V2_Construction Drawings_COMMENTS.pdf Markup Summary

SPROUL JUNIOR HIGH SCHOOL

UTILITY CONSTRUCTION PLANS

SS01

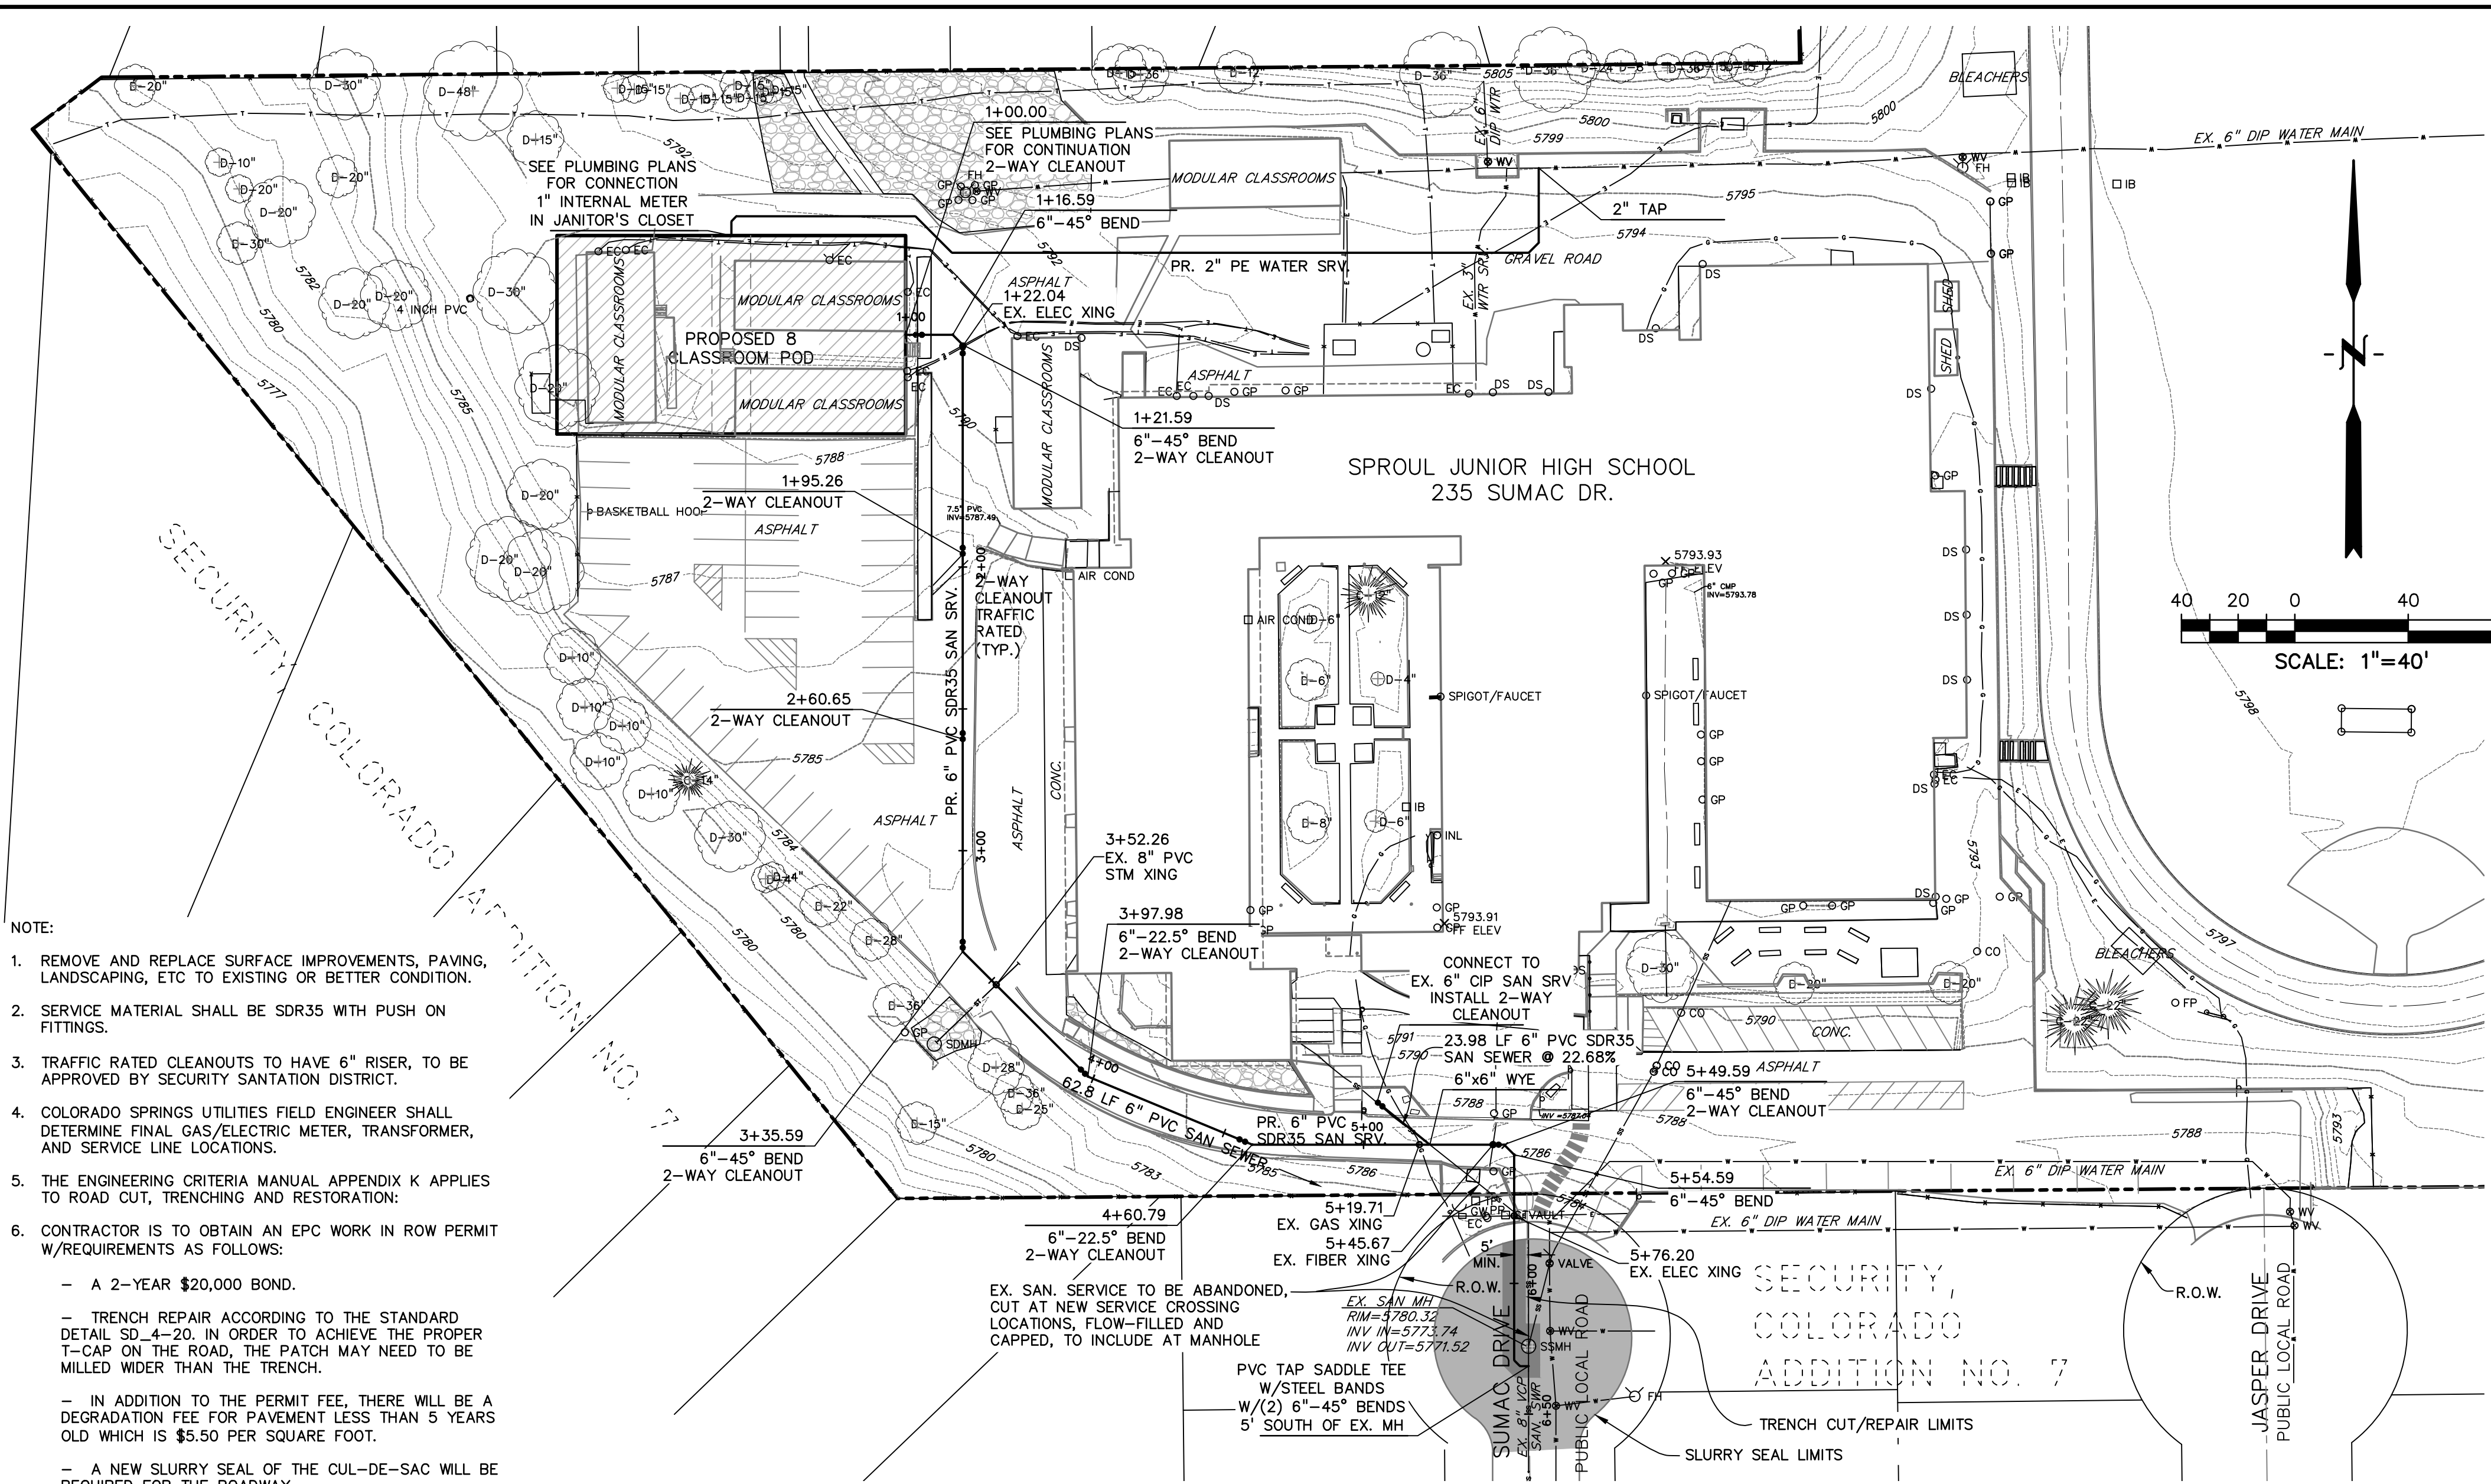
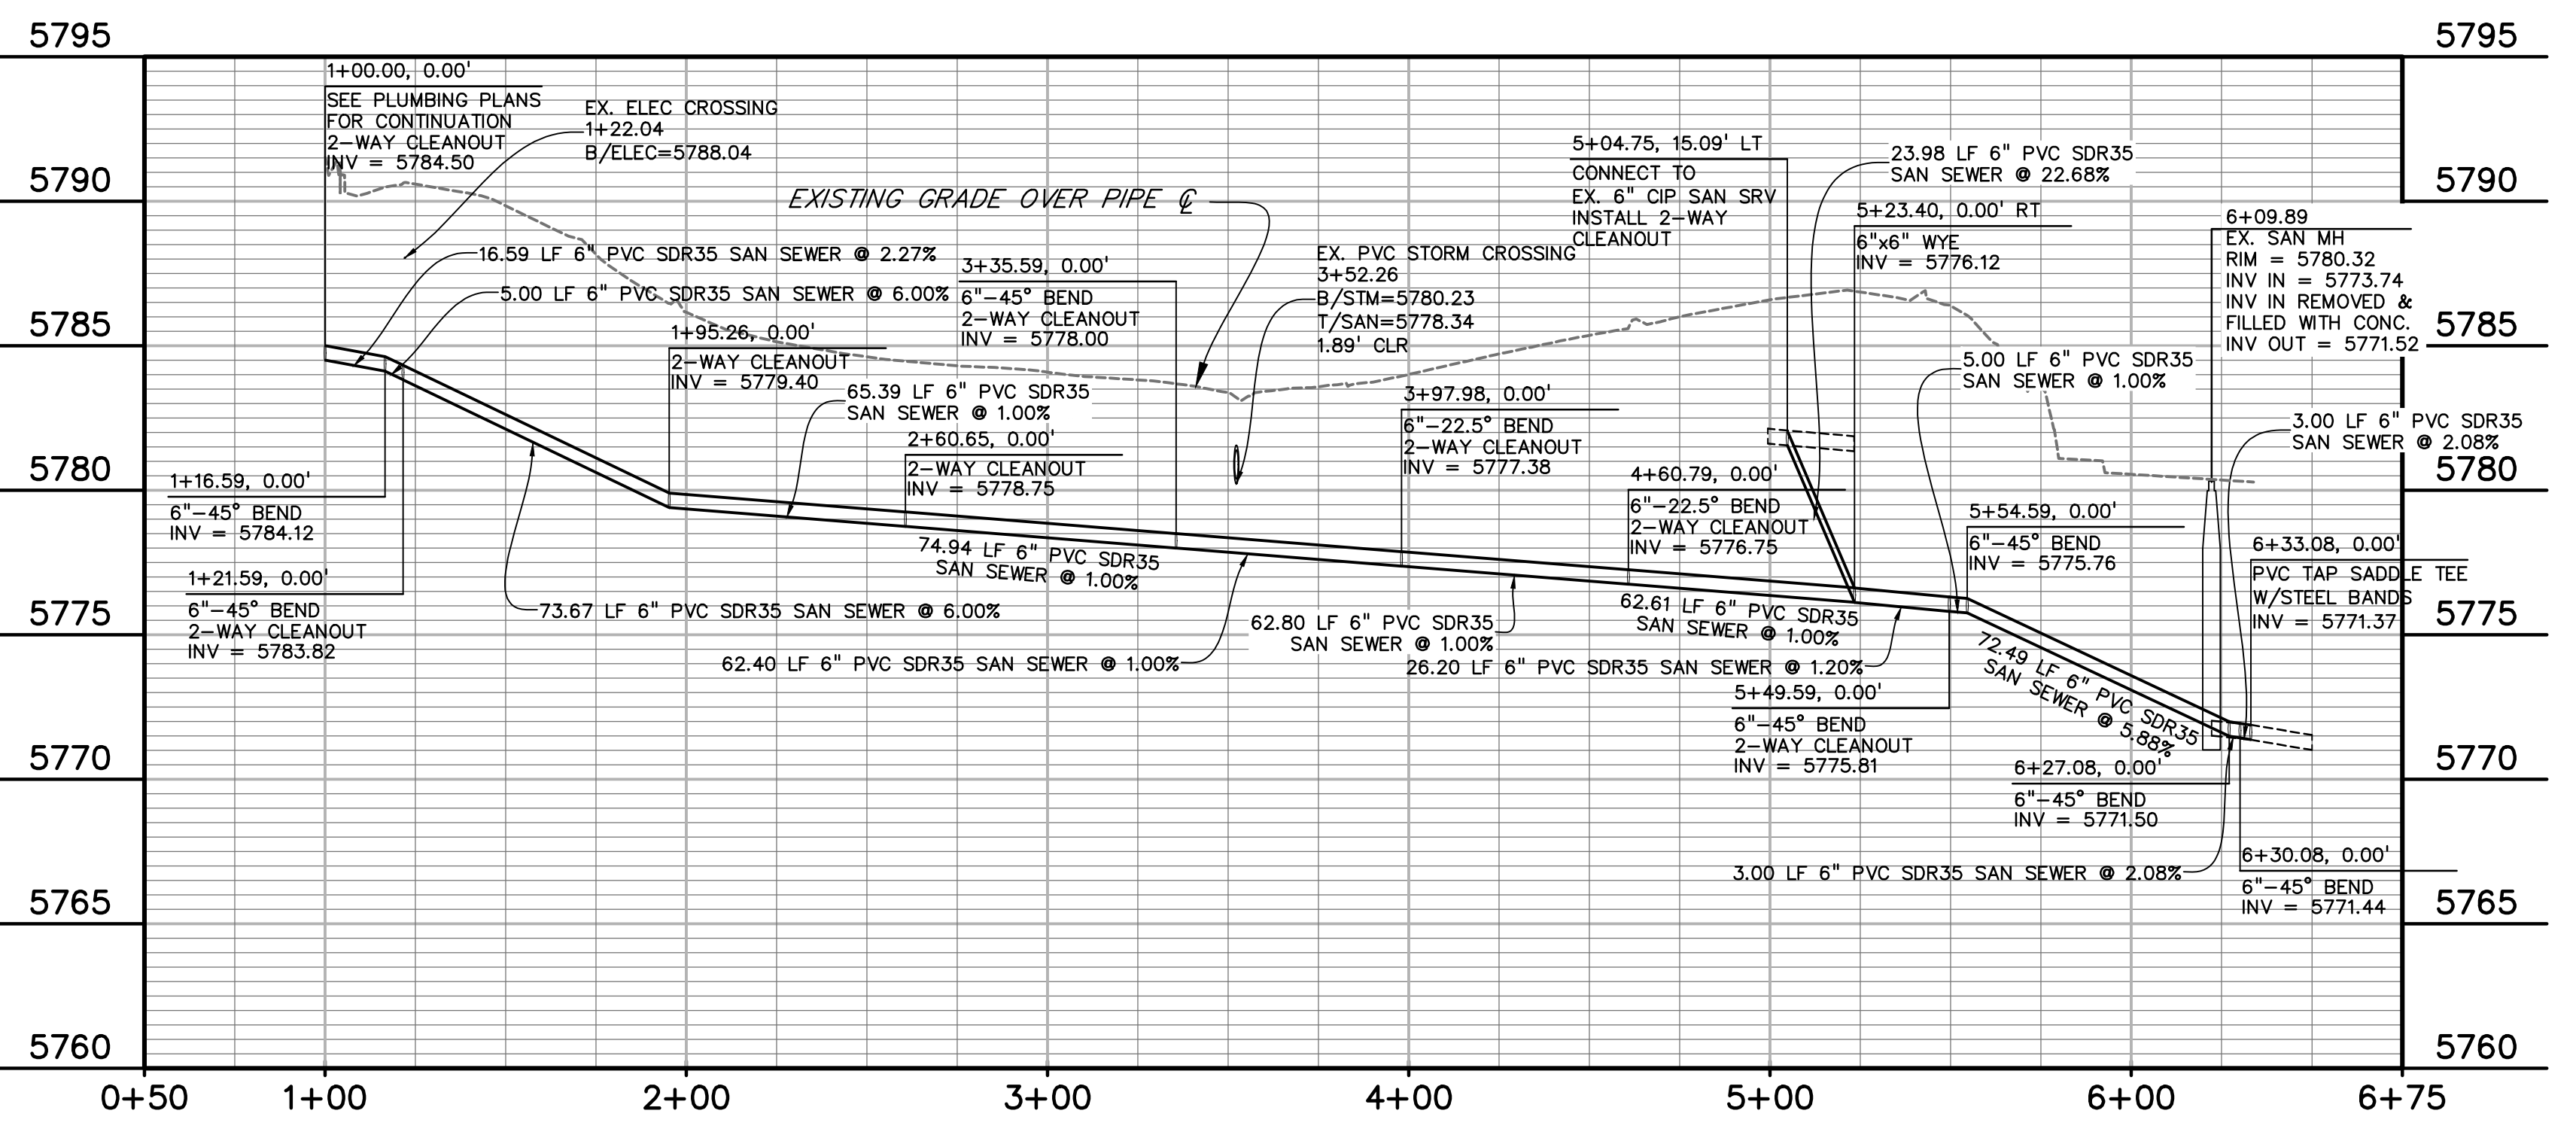
Please add Trenching Detail Notes from Section K.2 of Appendix K in the ECM to construction plans.

Removal and replacement of public sidewalk not included in plans. Please existing and proposed sidewalk in the vicinity of the proposed work.
